9918-HJCE-Lindum-IC -CS-001

**HUDDERSFIELD BUS DEPOT – PROPOSED CANOPY WORKS TO MACAULEY STREET.
KIRKLEES COUNCIL REF: 2024/48/92302/W - PLANNING CONDITIONS 13 & 33**

HBS-BWB-ZZ-FN-DR-S-1001

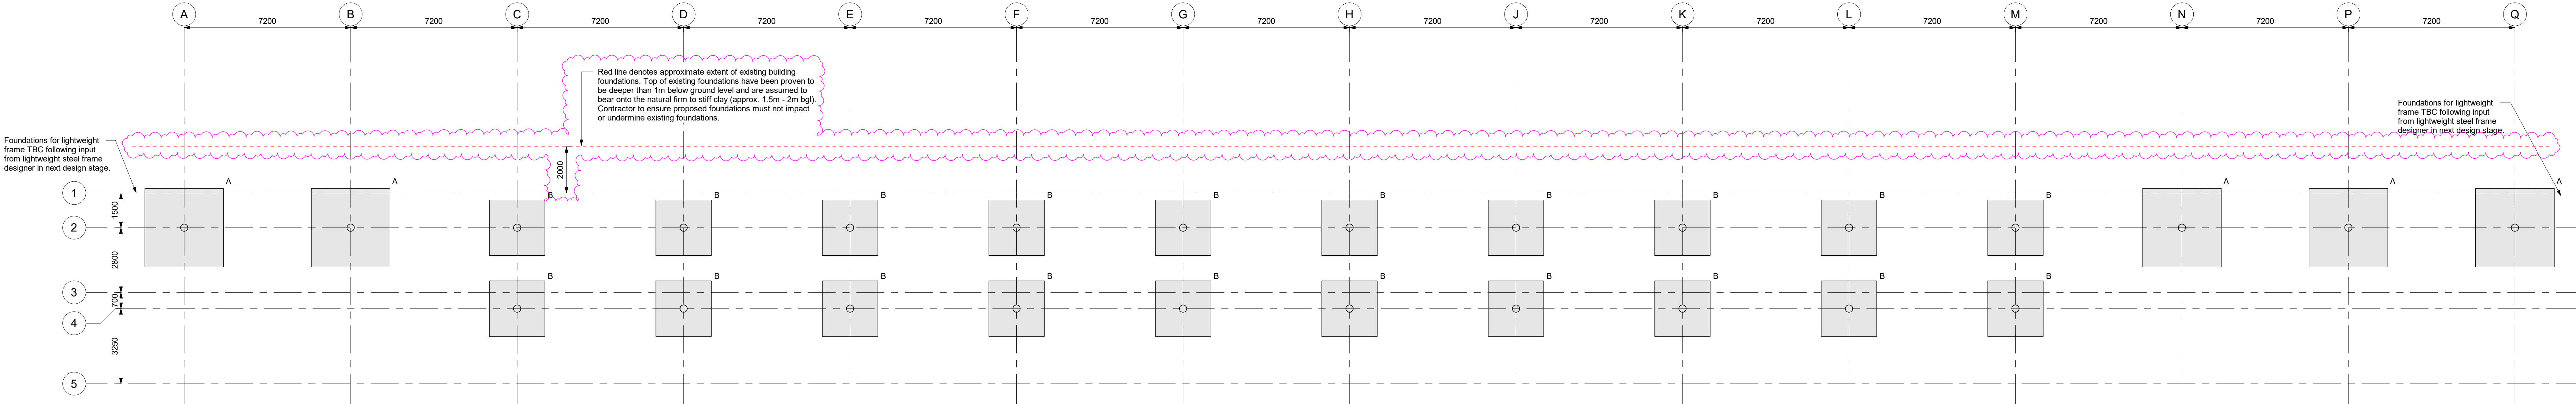
Prior to development commencing on phase two, as shown on plan 202335-SGPZZ-ZZ-DR-A-131105 RevP01 Combined Phasing, full details of the construction foundations including the proximity to the underground railway tunnels shall be submitted to, and approved in writing by, the Local Planning Authority. The development shall thereafter be constructed in full accordance with the approved construction details and retained as such.

HJCE response – The proposed foundation arrangement for the canopy structure is illustrated on the attached SGP drawing ref. 202335-SGP-ZZ-ZZ-DR-A-201101(P03) & BWB drawing HBS-BWB-ZZ-FN-DR-S-1001(P07). The canopy is proposed to be supported on shallow unreinforced concrete pad foundations, founded at approximately 2.0m below existing ground level.

Drawn:	R. Parkinson		Reviewed:	R. Duncan	
BWB Ref:	221692	Date:	May '25	Scale@A1:	1:200
Drawing Status					
Tender					
Project - Originator - Zone - Level - Type - Role - Number				Status	Rev
221692-BWB-INF-XX-D-C-0500				A4	P07

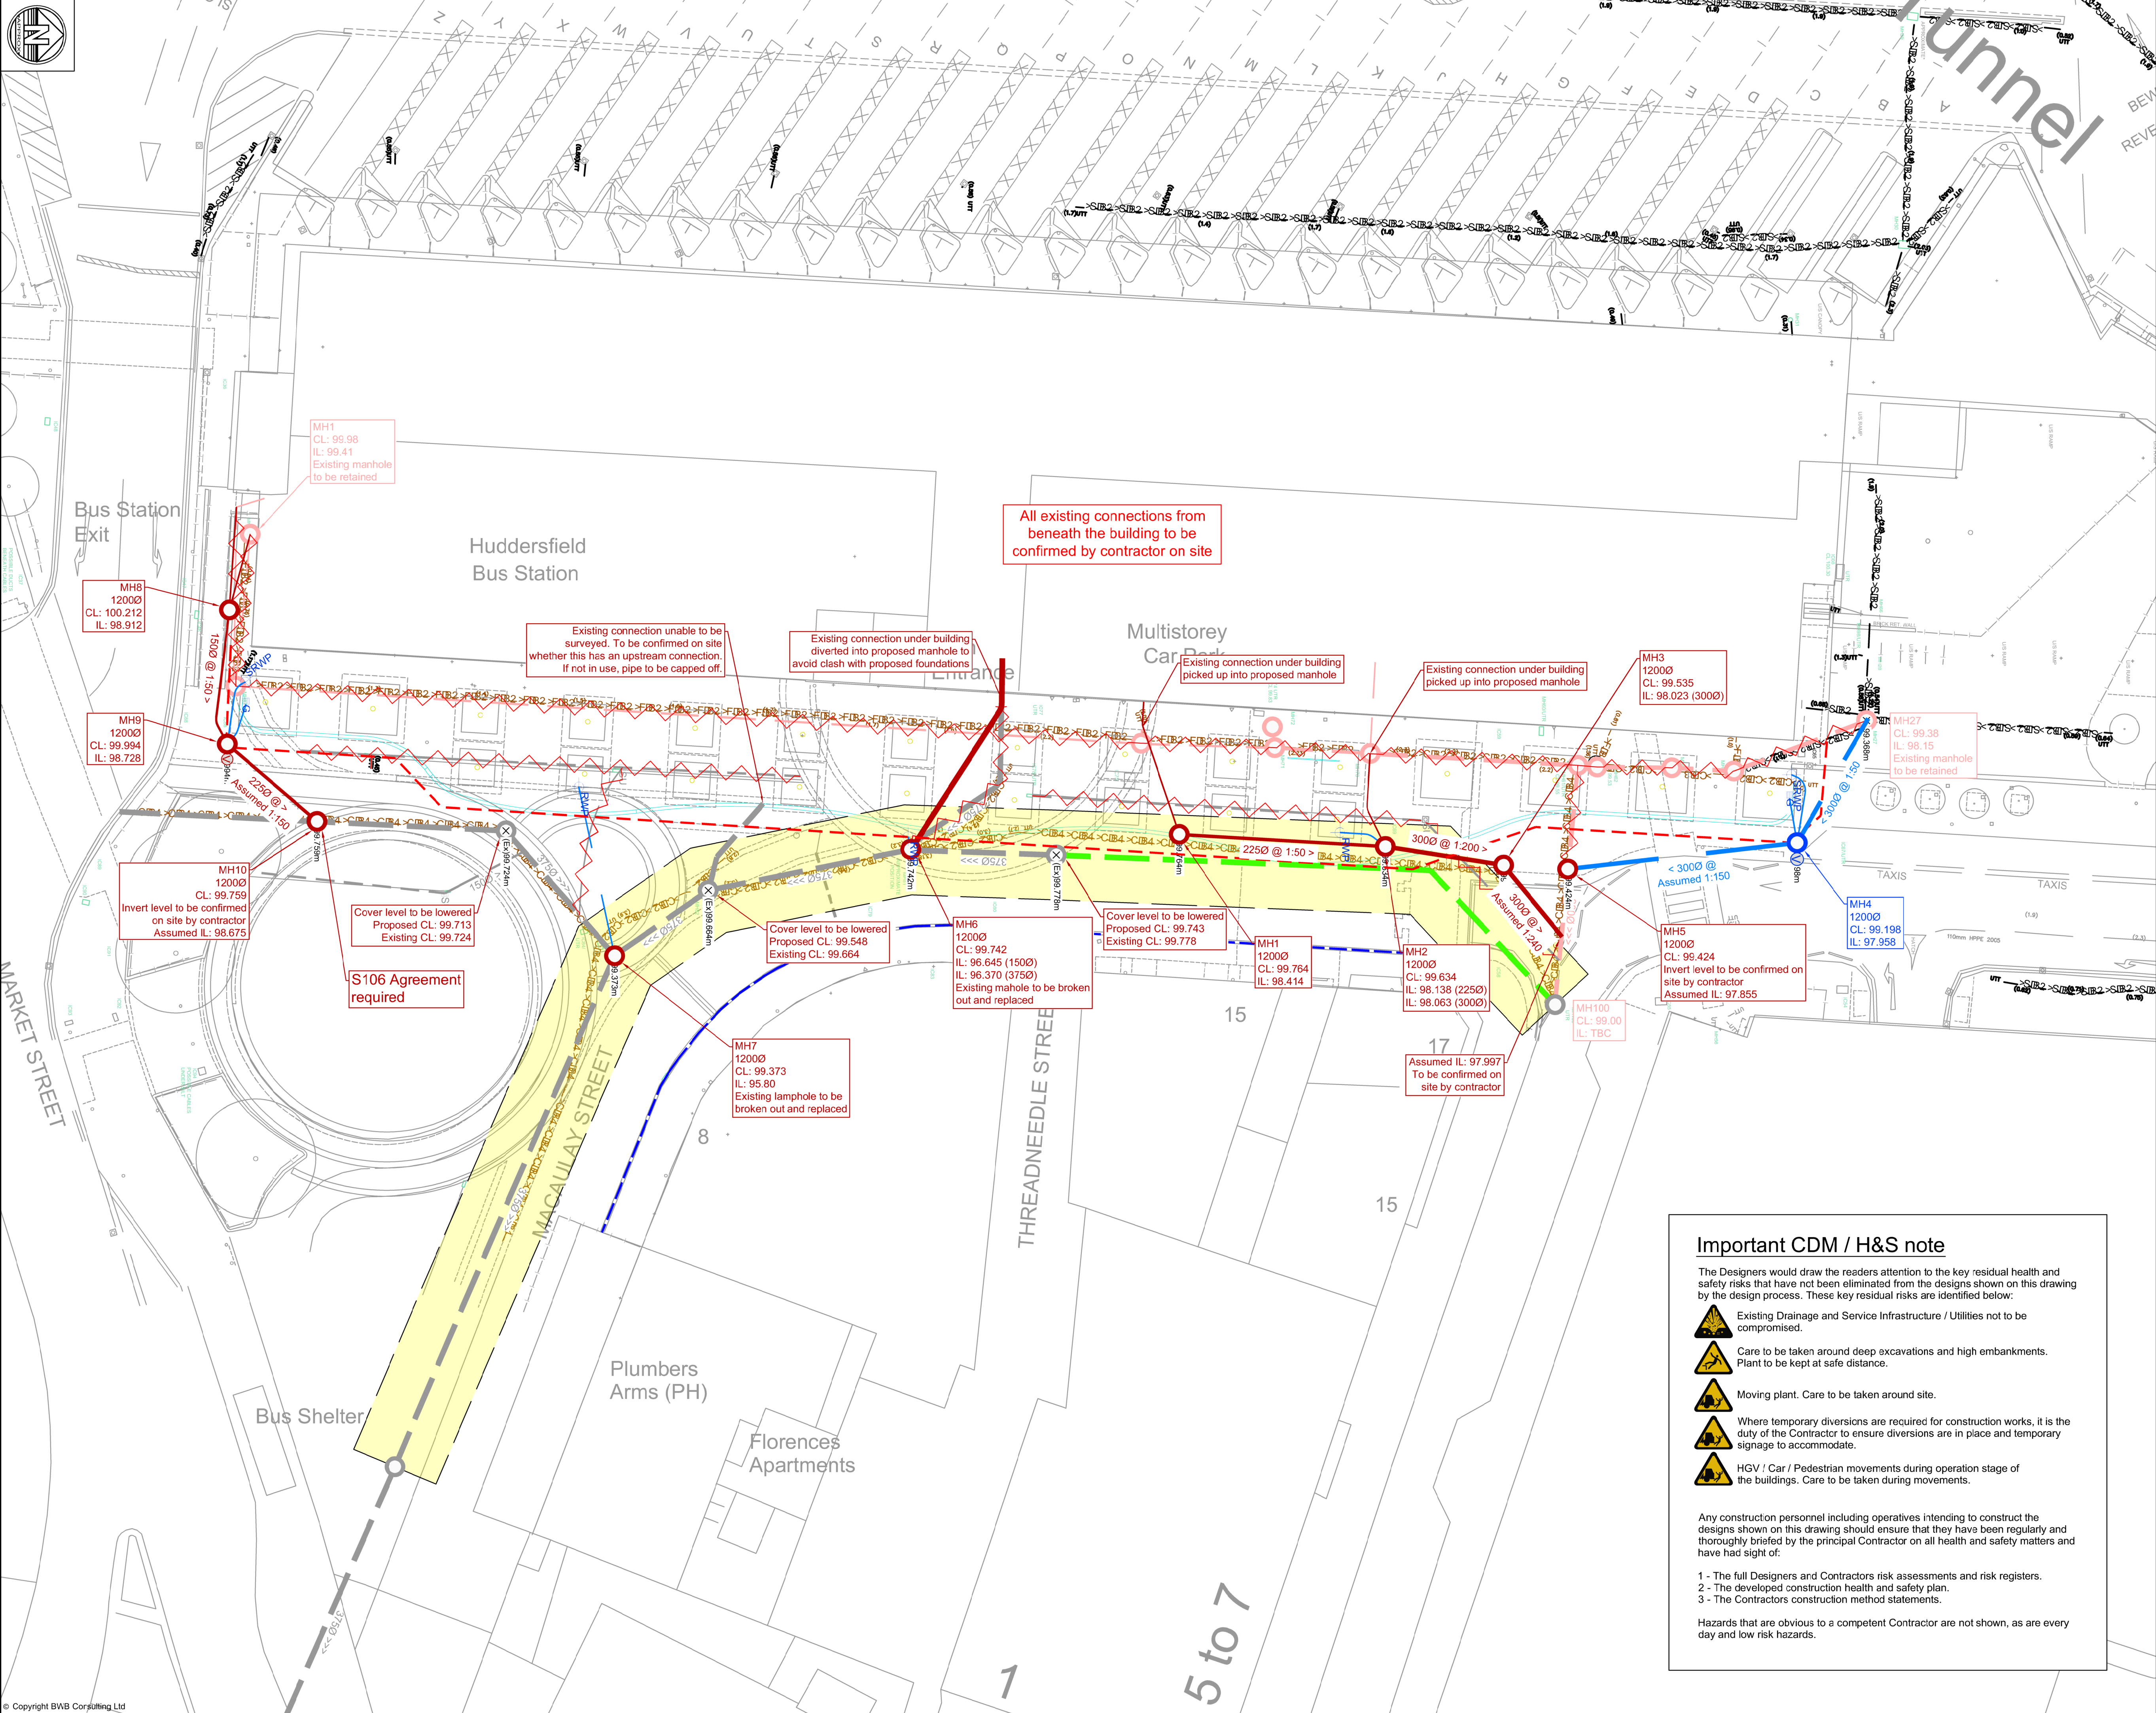
Prior to the commencement of phase two of the development, as shown on plan 202335-SGP-ZZ-ZZDR-A- 131105 Rev P01 Combined Phasing, and notwithstanding the recommendations in the FRA and Drainage Assessment by Weetwood dated June 2024, details of the proposed surface water mitigation measures specific to this phase shall be submitted to, and approved in writing by, the Local Planning Authority. The details shall include a timeframe for the implementation of the approved mitigation measures and the proposed management and maintenance arrangements. Thereafter the development shall be undertaken in accordance with the approved details

HJCE response – The proposed surface water drainage strategy is illustrated on the attached BWB Consulting drawing ref. 221692-BWB-INF-XX-D-C-0500-(A4)-P07. Surface water runoff from the proposed canopy will be collected via the green roof system and conveyed through a siphonic rainwater drainage system before discharging into a new below-ground drainage network. The system will ultimately outfall to the existing Yorkshire Water public combined sewer located along the bus station frontage on Macauley Street.

As identified within the Drainage Assessment prepared by Weetwood, “*there are no proposed changes in contributing areas, and the existing drainage system will continue to be utilised.*” On this basis, no formal surface water attenuation or additional mitigation measures are proposed as part of the development.

Whilst no formal attenuation infrastructure is proposed, the inclusion of the green roof will still provide a degree of surface water betterment. The green roof will assist in filtering runoff, provide initial rainfall interception and storage, and contribute towards a reduction in peak surface water discharge rates during smaller rainfall events.
